From: Anita Gardner
Sent: 07 January 2019 09:54
To: Planning.Responses
Subject: FW: FG/171/18/DOC - Peugeot Garage Premises, Littlehampton Road,
Attachments: 17036 - Construction Management Plan (RevC).pdf

Environmental Health: Agree to discharge of Condition on the basis of the attached Construction Management Plan (HNW Architects Job No 17036, Revision B, 07.12.2018).

Environmental Health: Application for discharge of conditions. Further information required.

Honda Worthing 11-07-18 EXT REV 0

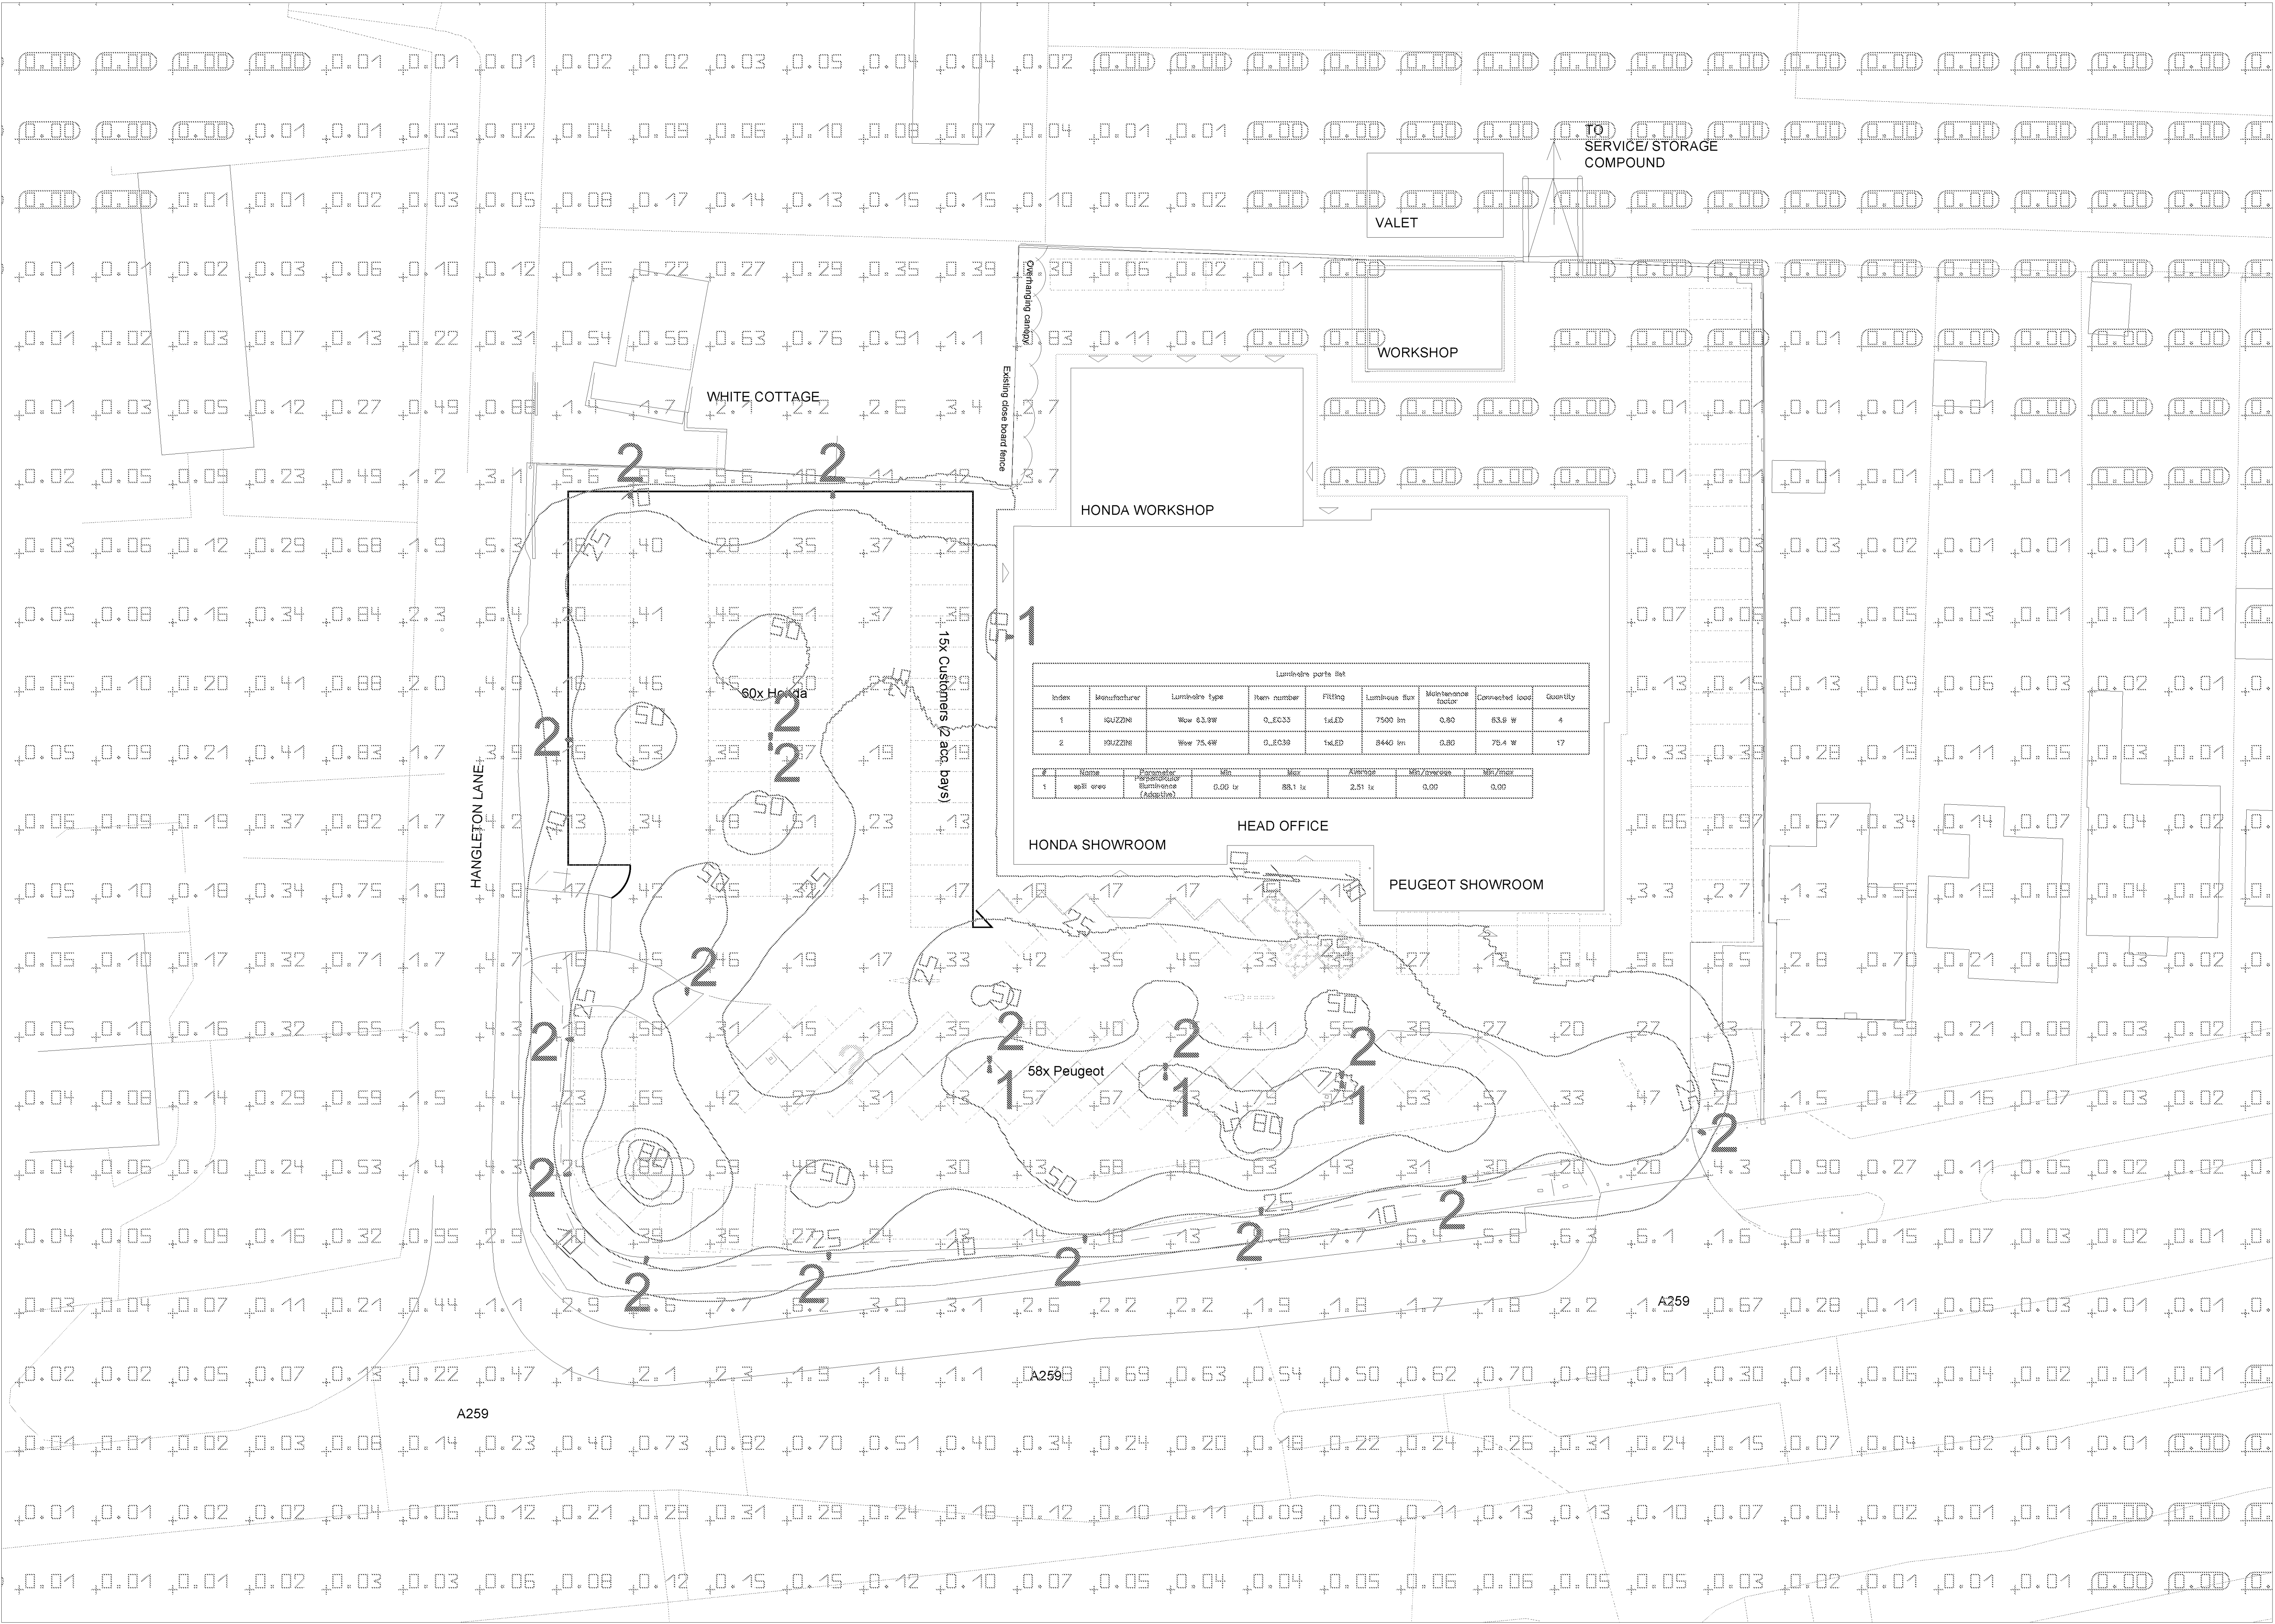
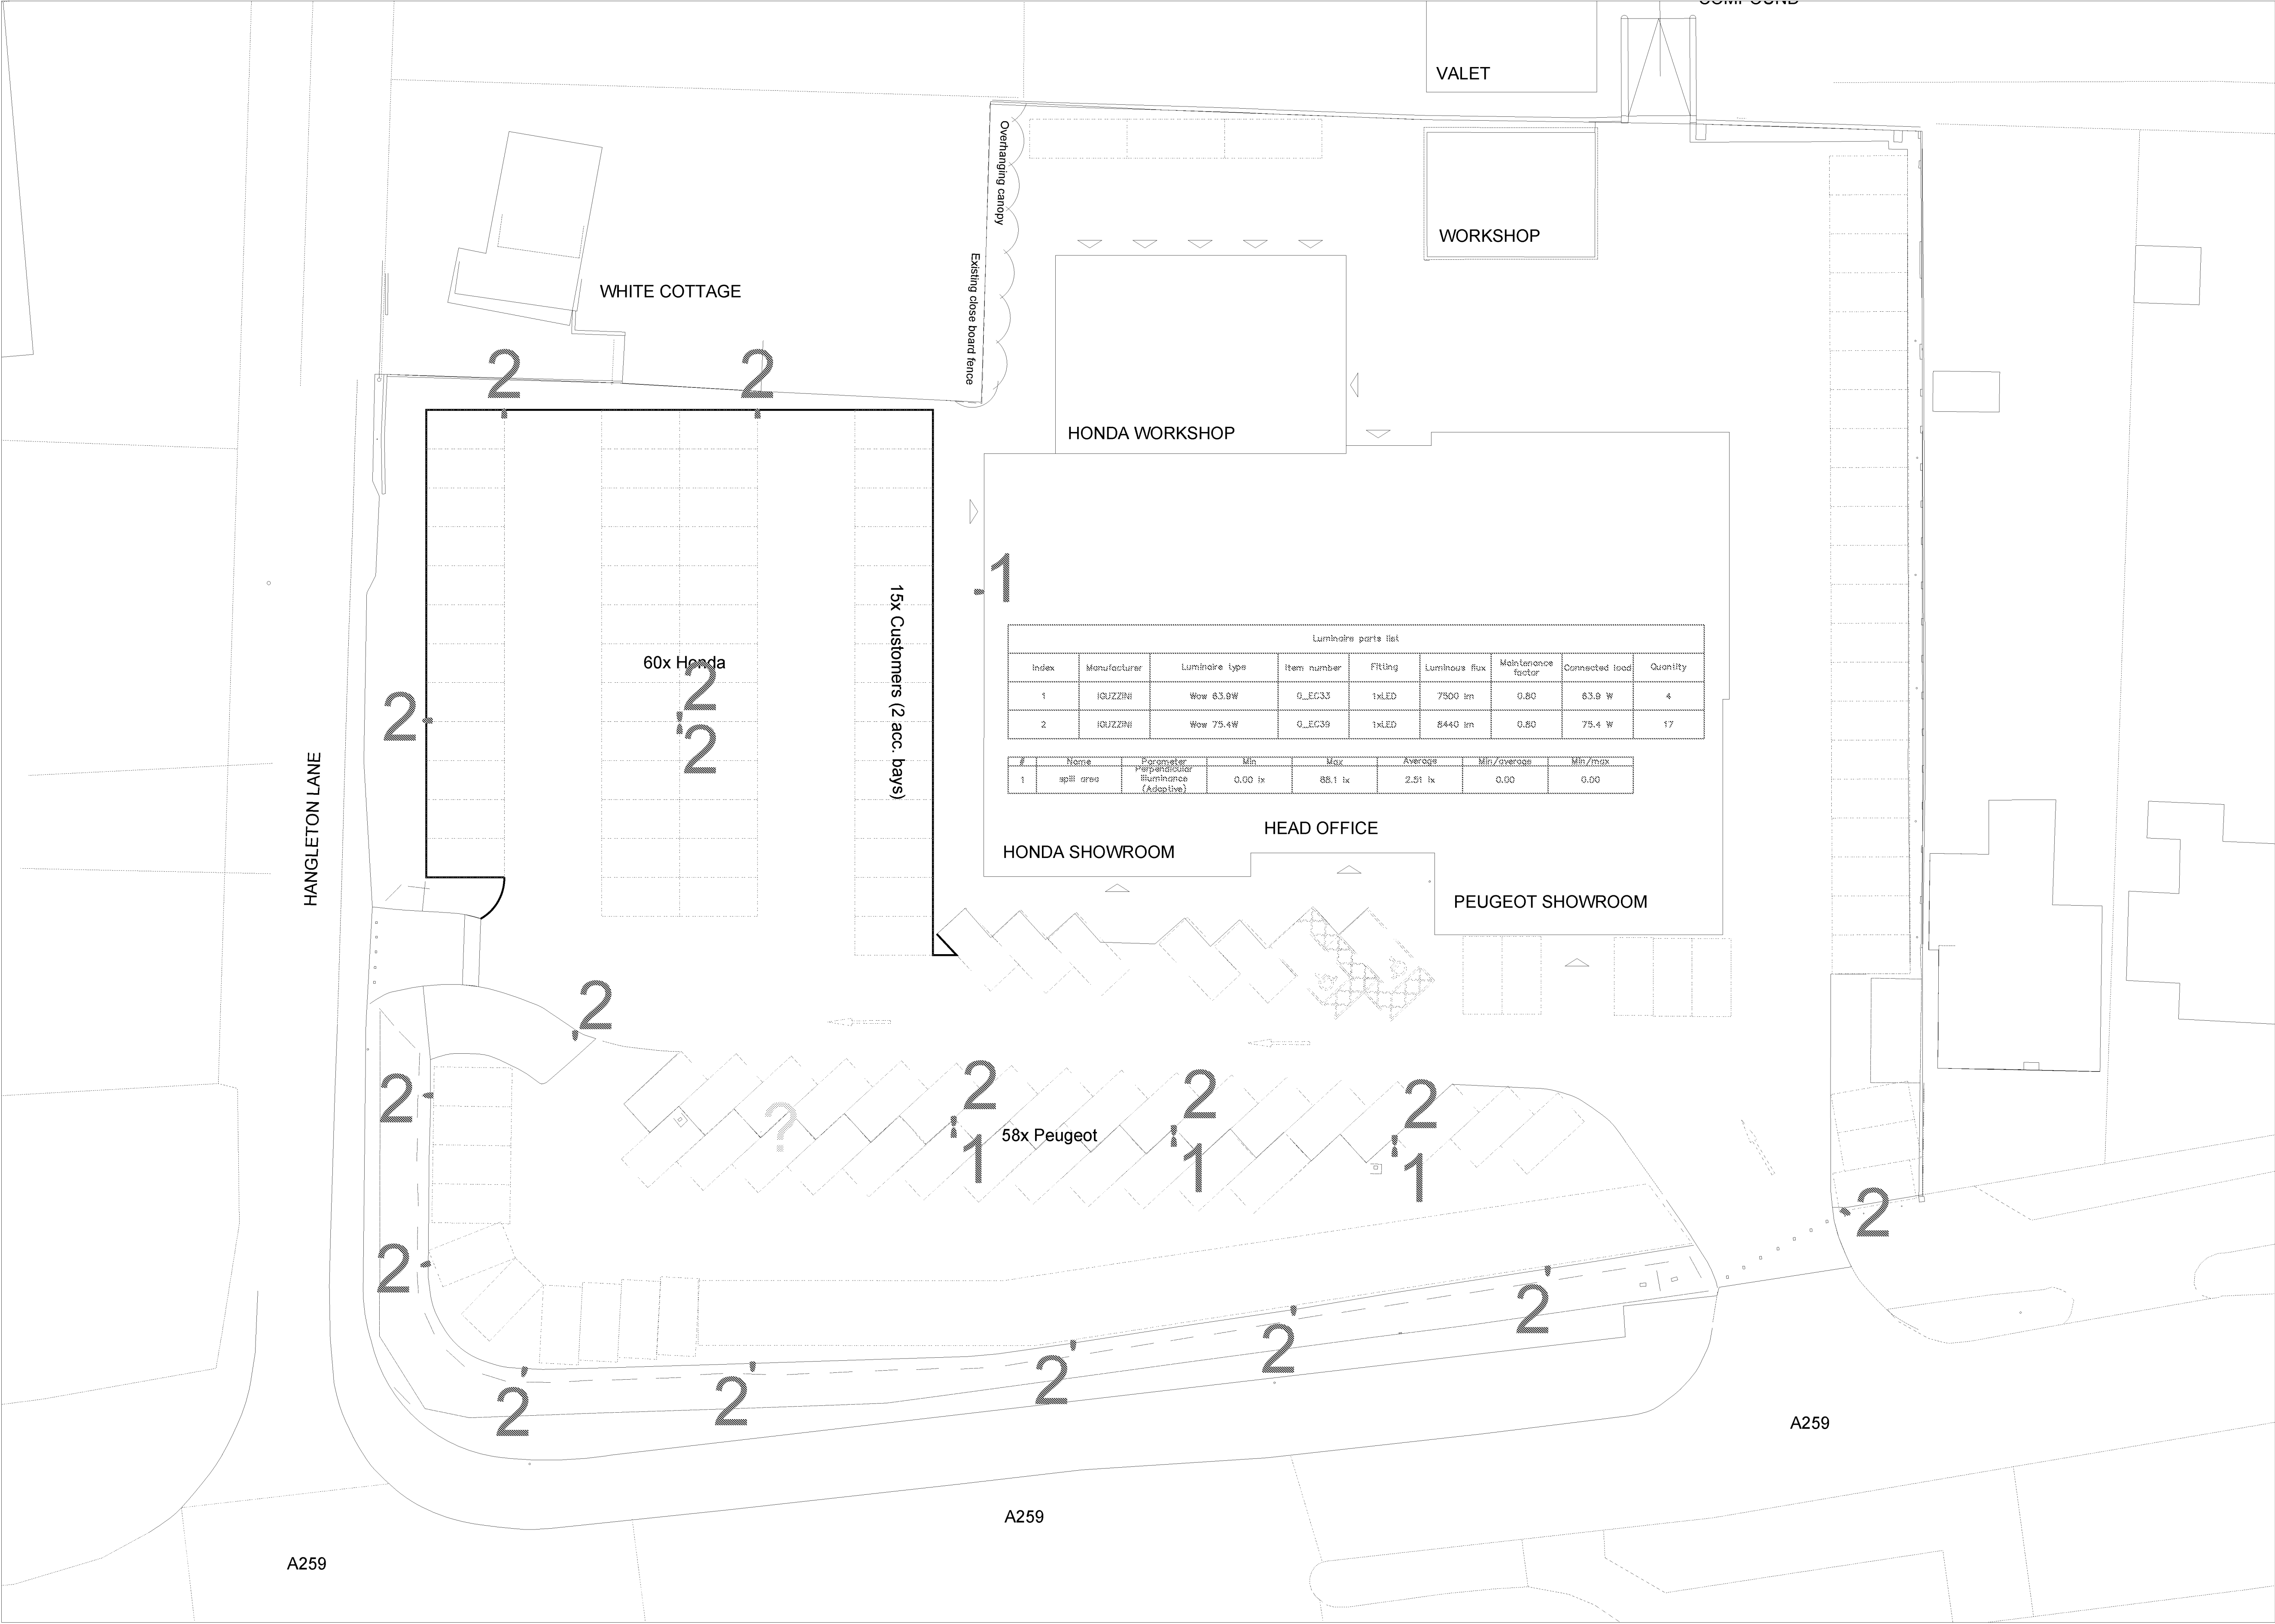
Lighting Plan: Lower level lighting, specified as 'Type 1' to be provided to areas proximal to sensitive receptors and to the north of the site in order to prevent detriment to the amenity of these properties and South Downs National Park.

I understand that our electrical engineer will contact the EH officer on her return from leave on Monday to discuss the external lighting design comments further. Hopefully to a resolution asap.
